City of Gosford Design Advisory Panel

Meeting Agenda – Design Reference Group workshop

Details	
Name	City of Gosford Design Advisory Panel – Design Reference Group (DRG)
Location	Department of Planning, Industry and Environment (DPIE) 320 Pitt Street Sydney, Level 24 Blue Gum Room (meet in foyer)
Date/Time	Tuesday 15 October 2019, 12:30pm – 2:00pm
Chair	DRG member
Attendees	Robert Hodgkins (DPIE) Louise Starkey (DPIE) Lisa Ford (DPIE) Paul Walter (DRG) Peter Smith (DRG) Johann Strey (ADG) Anthony Kelly (ADG)
Site	Gateway Shopping Centre, 237 Mann Street, Gosford

1 GROUND FLOOR PLAN
aaa 1 : 500

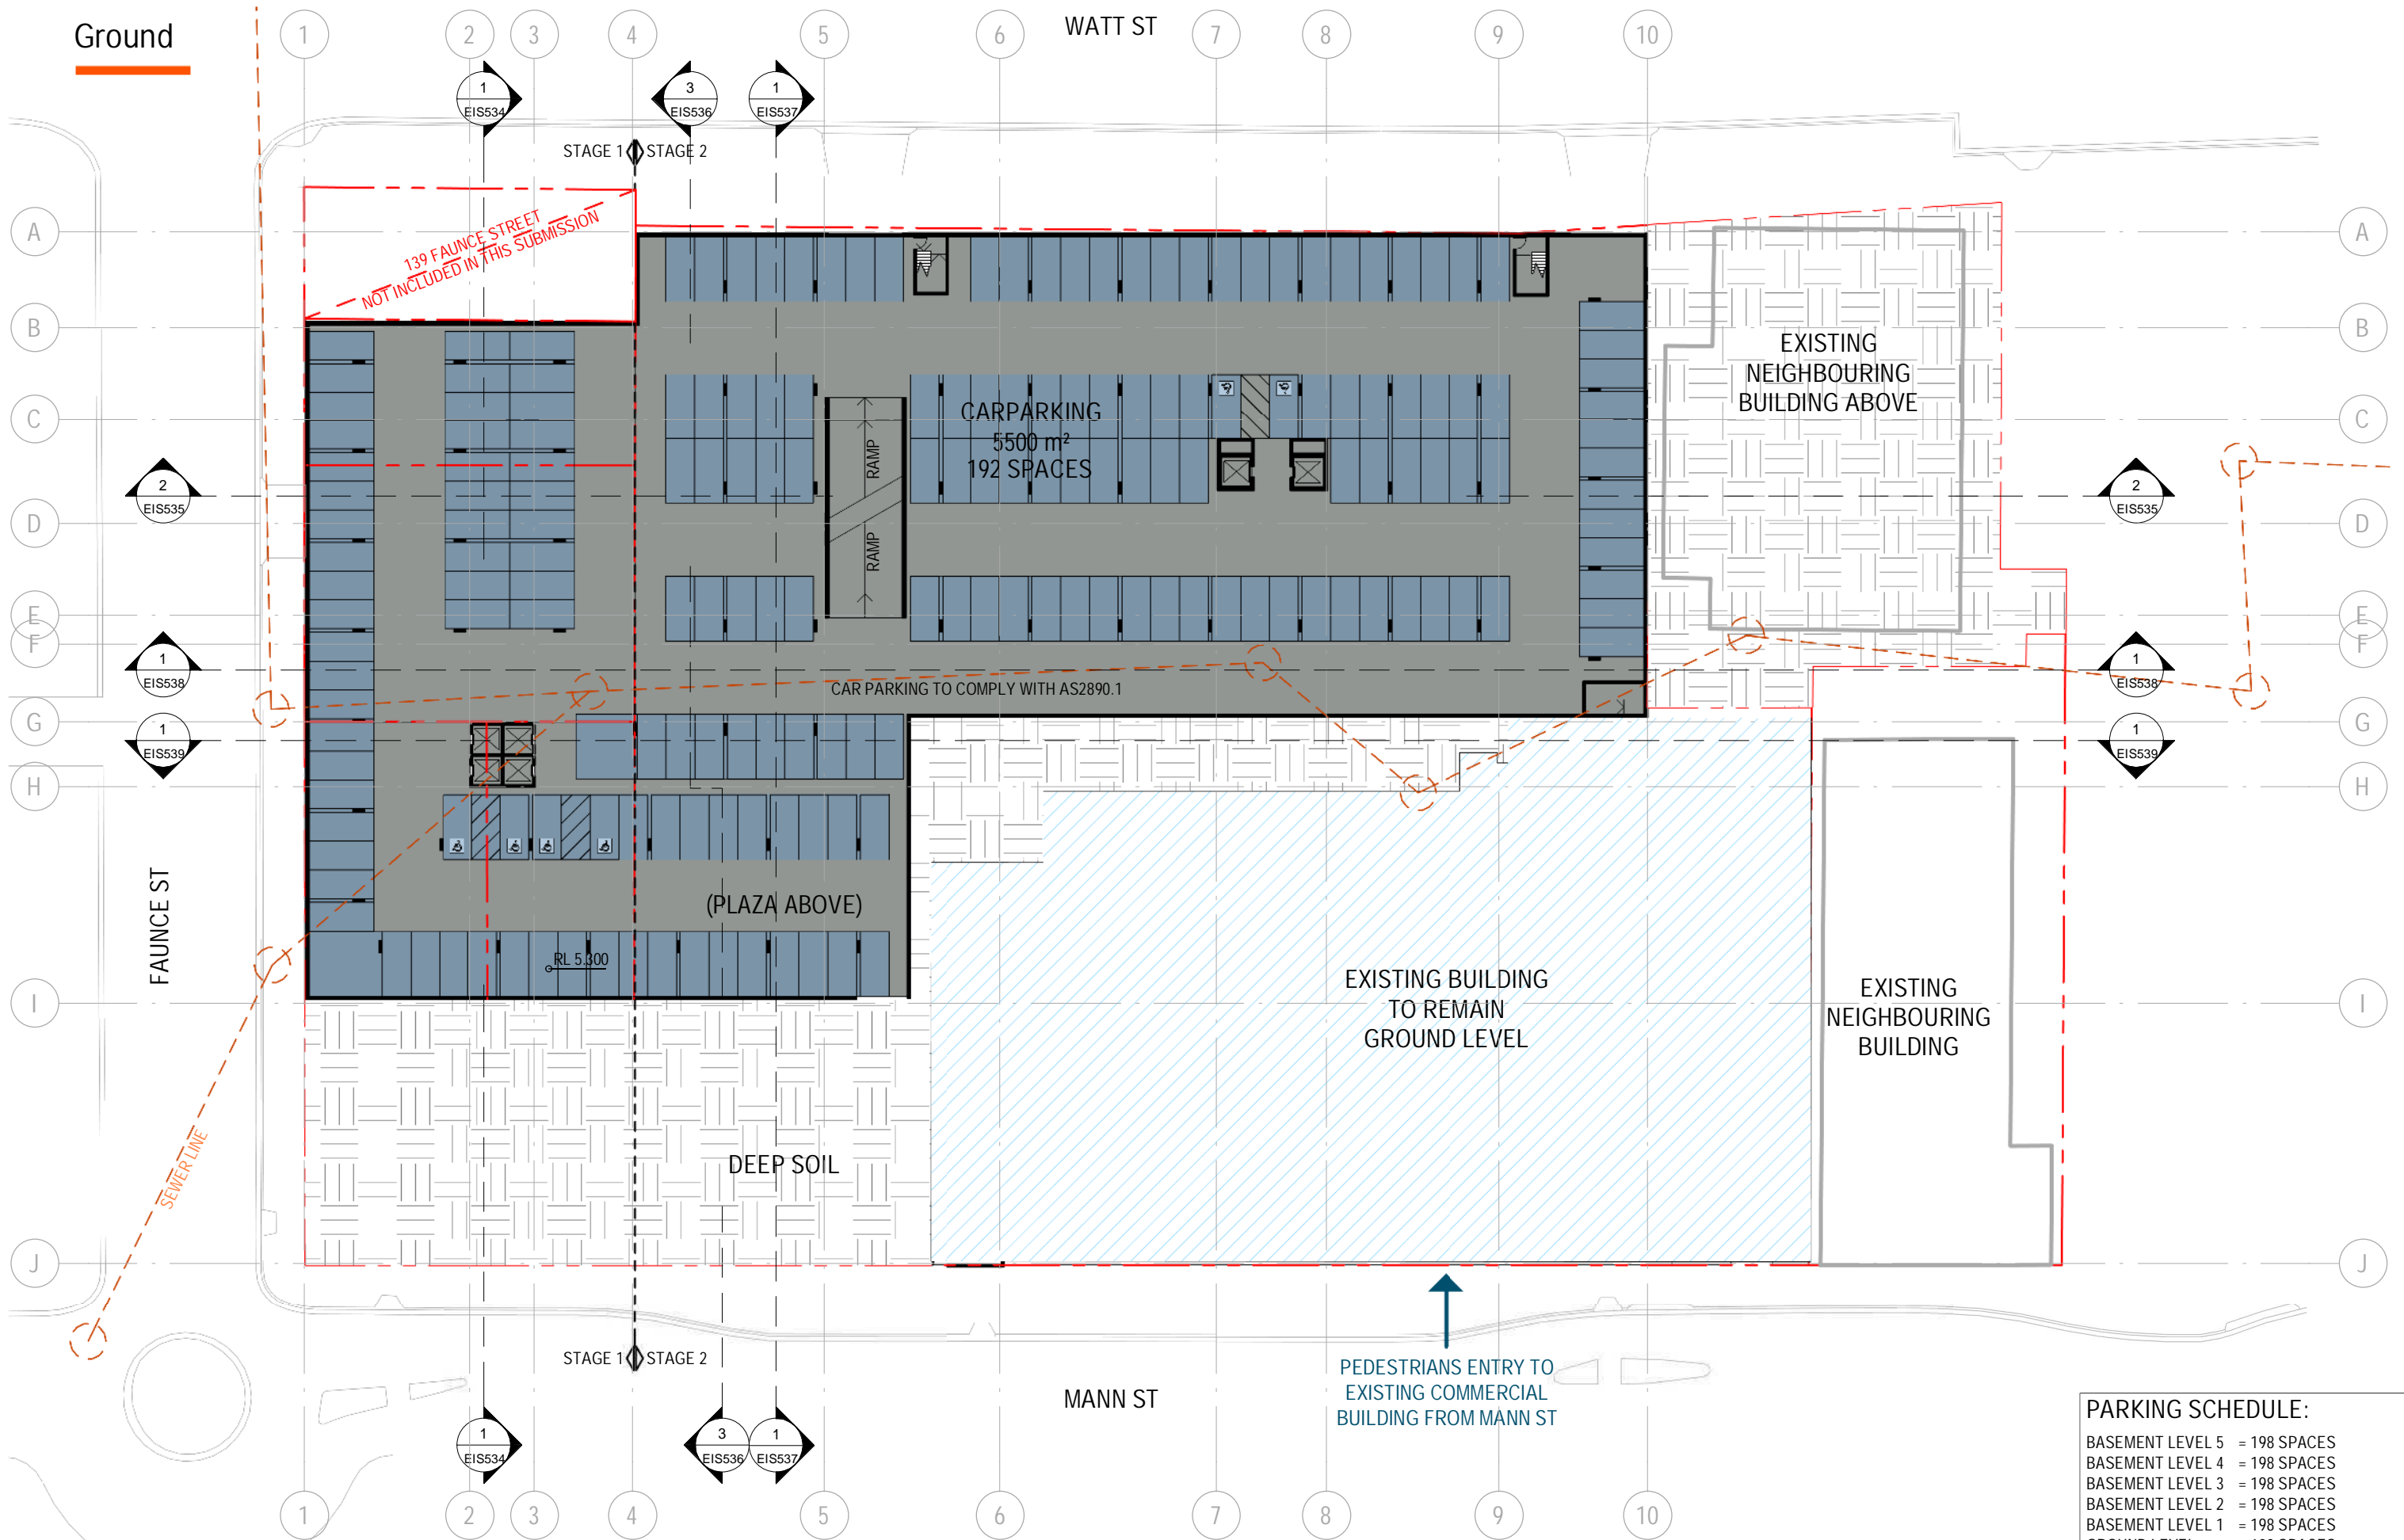
- Ground level – The DRG is still not clear how the 'ground level' and 'level 1' relates to the street level. The level 1 activities suggest direct pedestrian connection to the square and street – what visibility does 'office / storey' area on the ground plan have?
